PINS ref: TR010054

26 March 2021

M54 to M6 Link Road Scheme – Deadline 7

Drawing Title  
**GENERAL ARRANGEMENT  
REGULATION 5(2)(O)  
SHEET 4 OF 10**

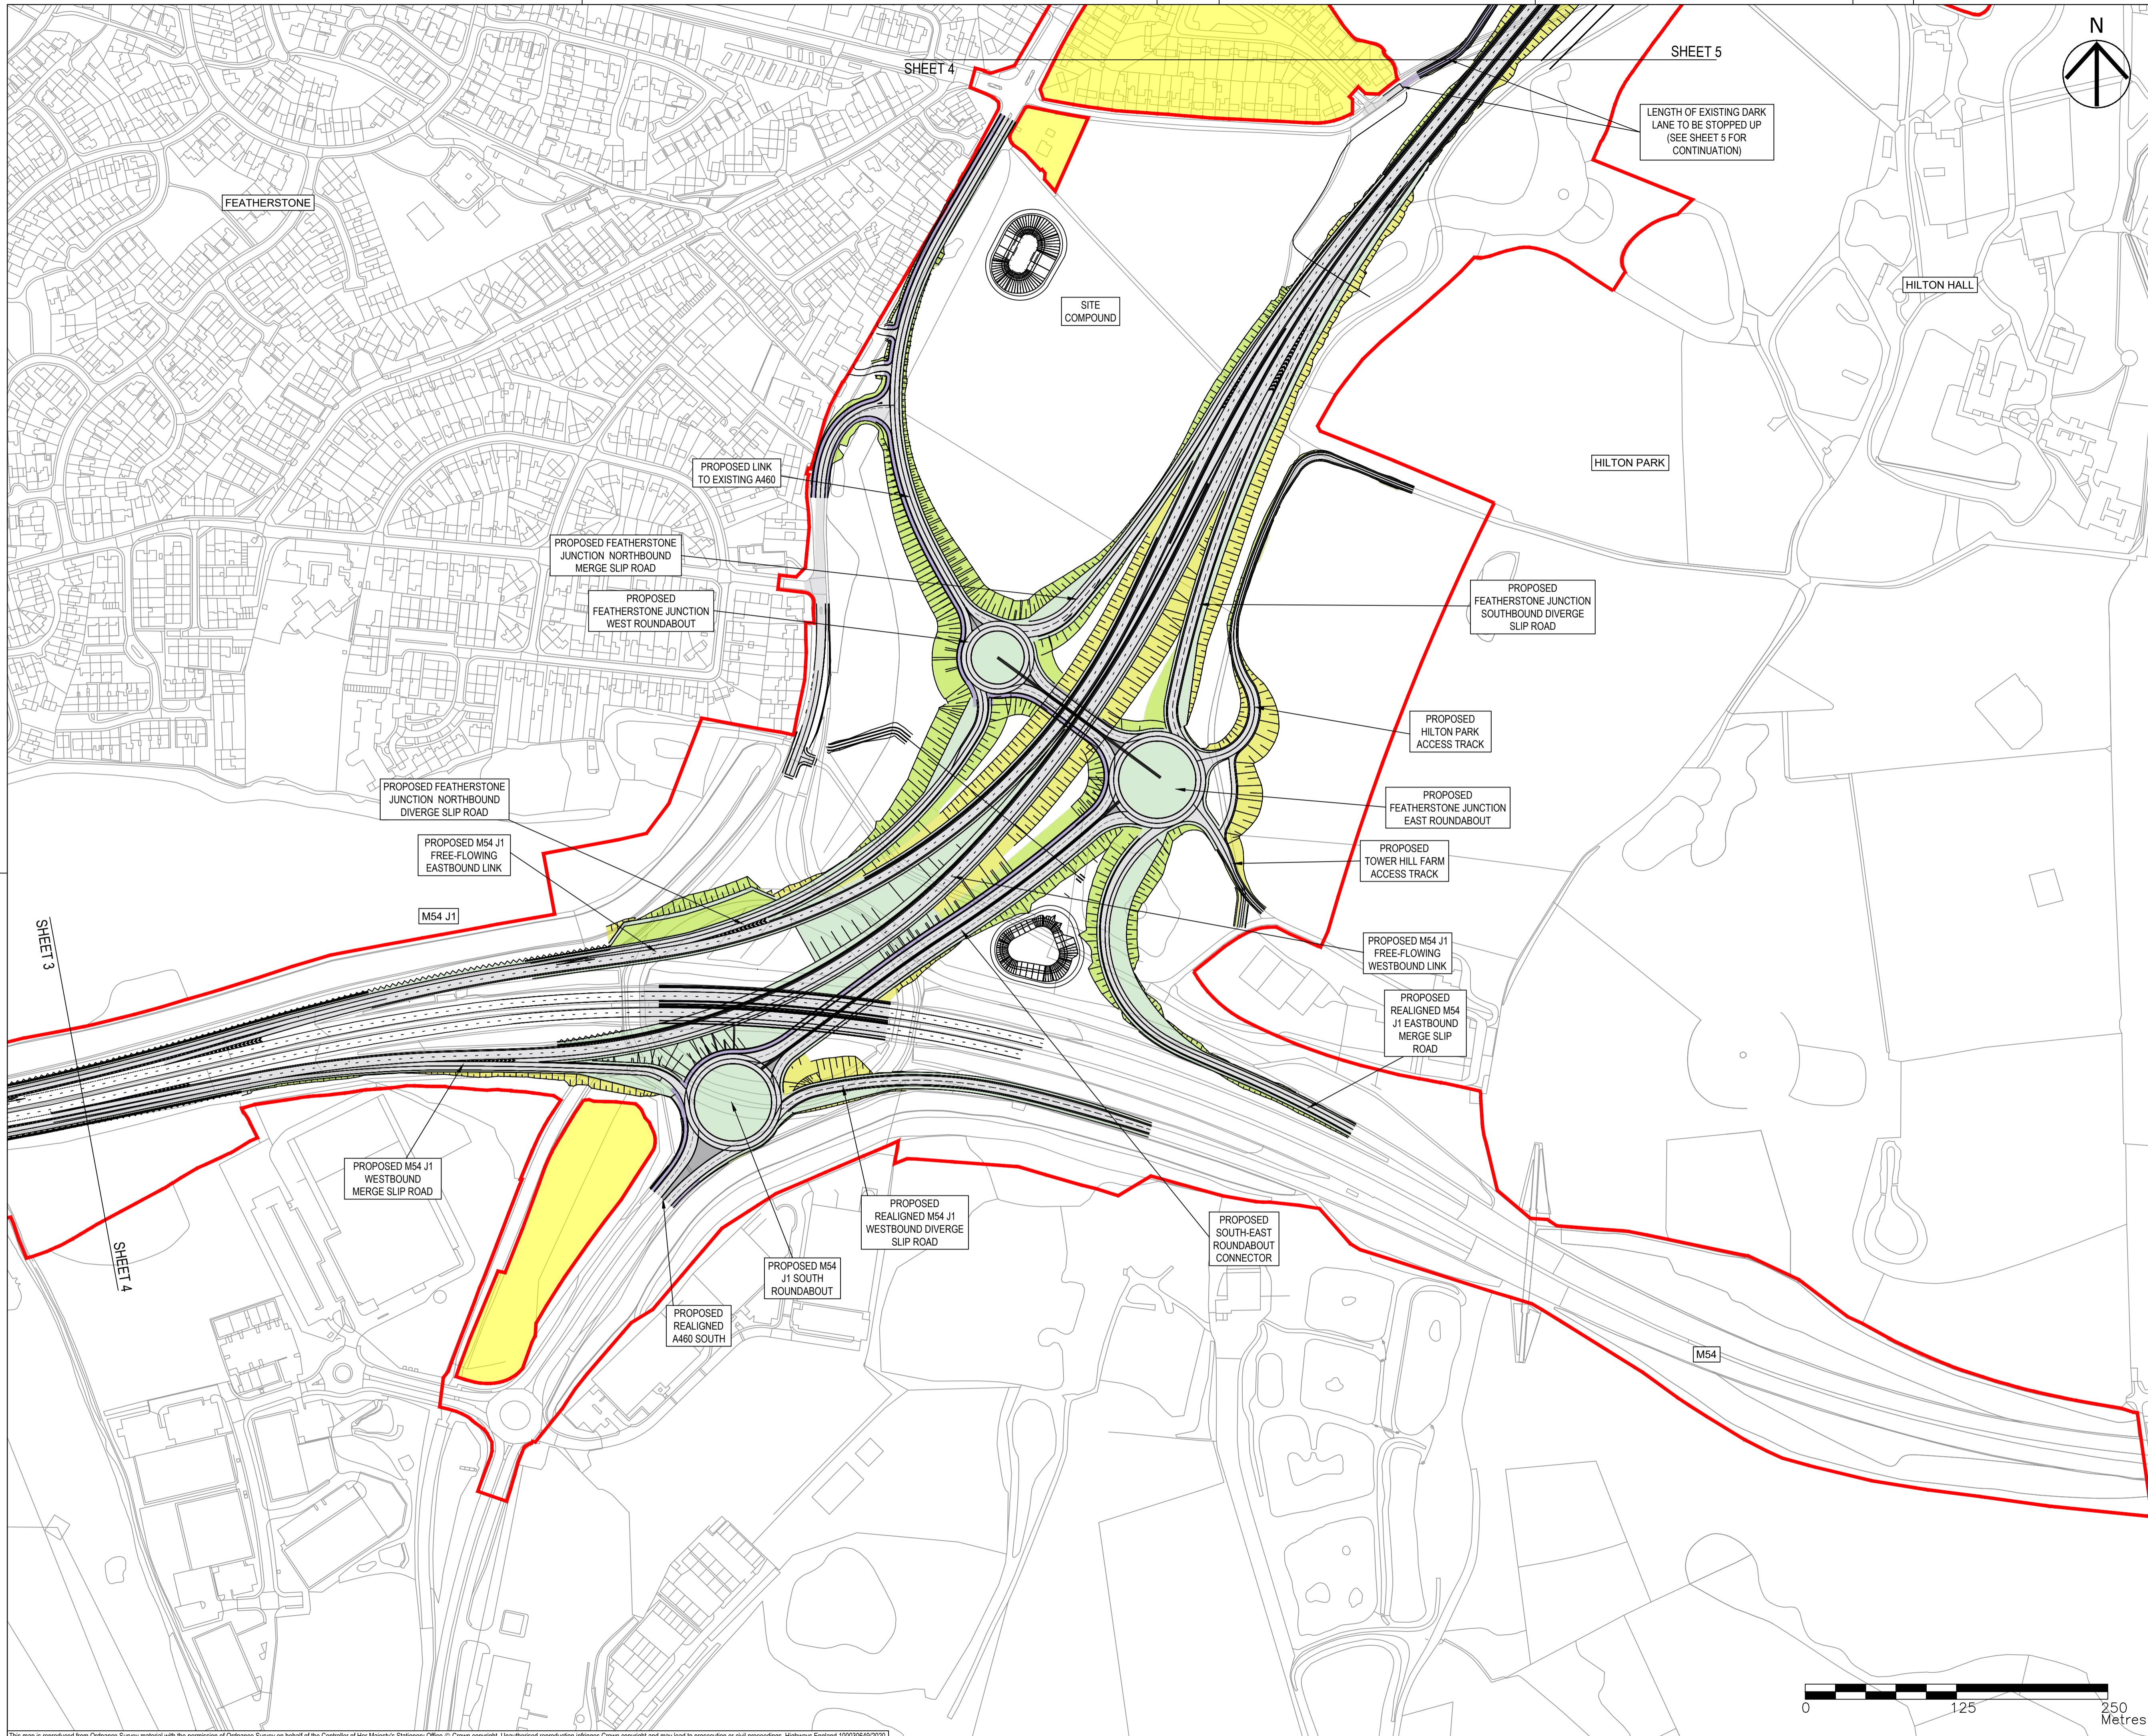
Changes to A460 tie in

Minor changes to the design have been made to the tie in detail between the new and old alignment of Cannock Road at the request of Staffordshire County Council. See page 42 of the Statement of Common Ground with SCC submitted at Deadline 7 for a record of this agreement. This change has been reflected in the General Arrangement Scheme Layout plans and all other plans that have the General Arrangement overlaid. An additional Work Item (Work No 90) has been added, and two Work Items (Work No 18 and 19) have been removed from the Works Plans, draft DCO and Statement of Reasons submitted at Deadline 7 to reflect this minor design change.

2.5	General Arrangement Scheme Layout	P04	Minor amendments to tie in detail between the new and old alignment of Cannock Road and change in priority at Cannock Road/ Avenue junction (change to Sheet 4 only).

Drawing file: TR010054 / TR010054-001020-TR010054 M54 6.3 Figure 2.7 Draft Masterplan Sheet 5 of 5.pdf

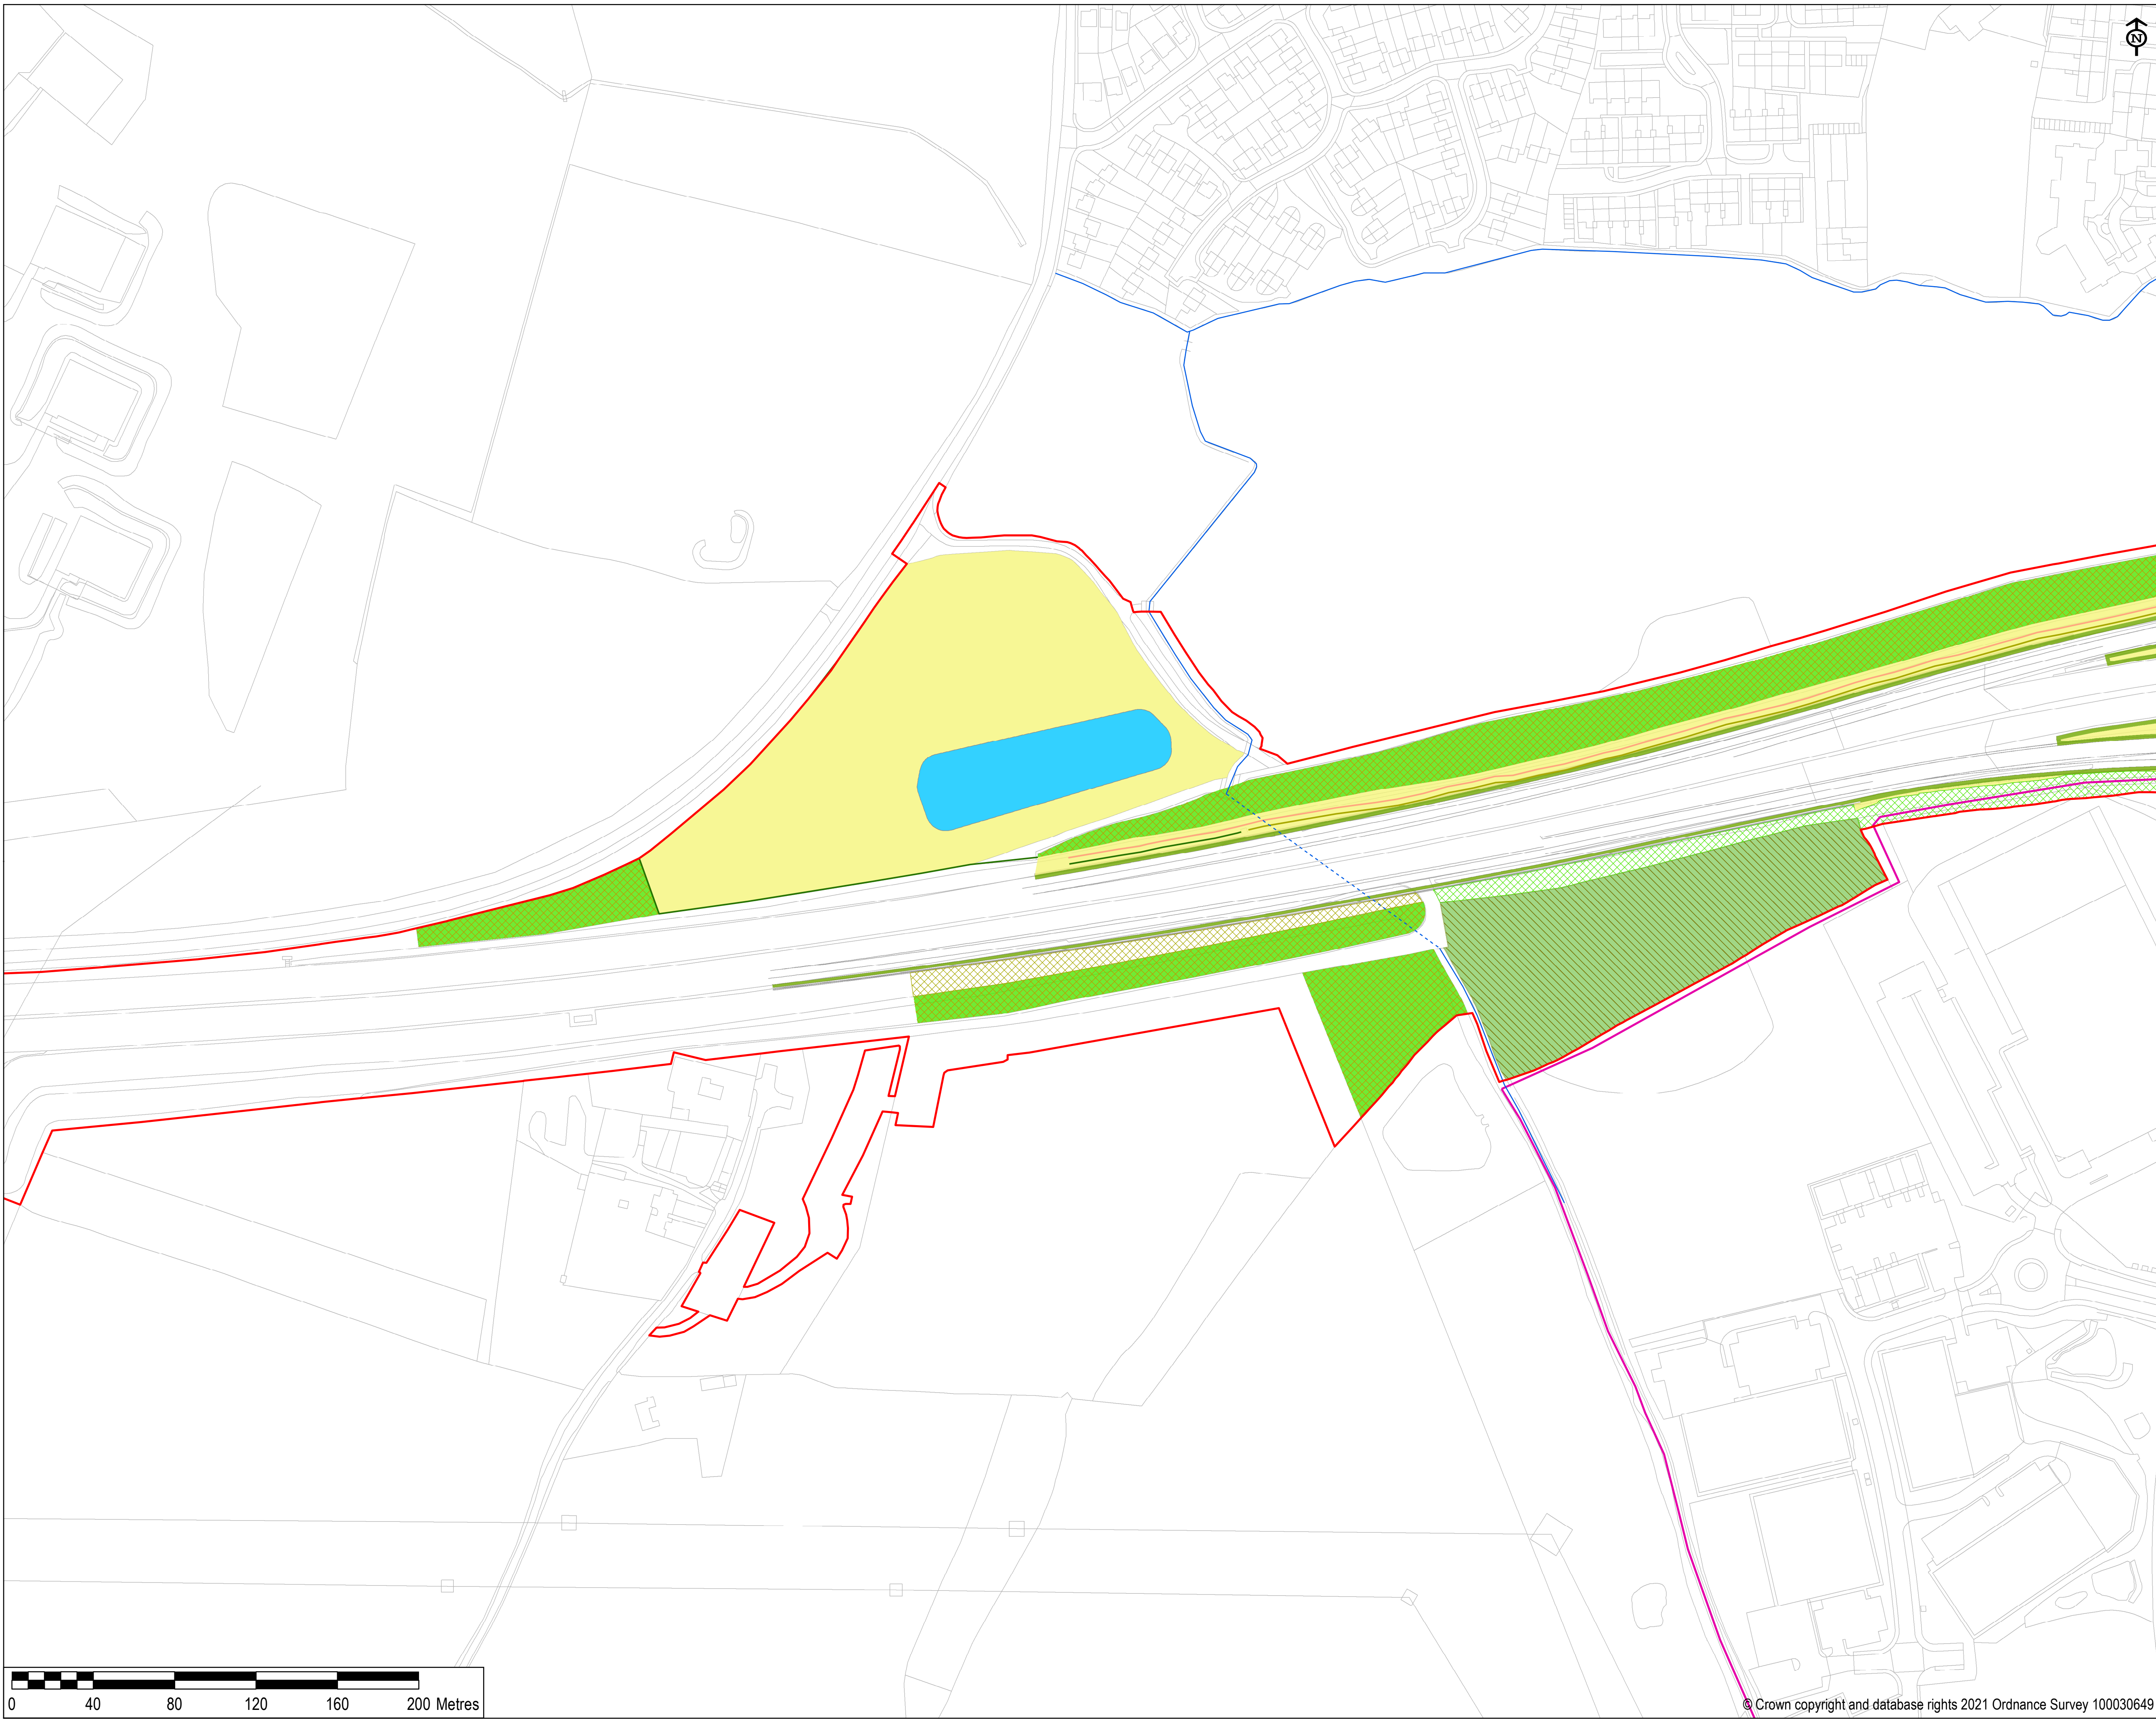
6.2	Environment masterplan Figures 2.1 to 2.7.	P16	Update to add in new footpath from Cannock Road and to update changes to detail at the A460 tie in.
6.8	Tree Preservation Order Impact/Removal Plans (clean and tracked)	3	Amended to add in tree preservation order/tree removal plans as requested by the ExA in their comments on the draft DCO (26/02/21).
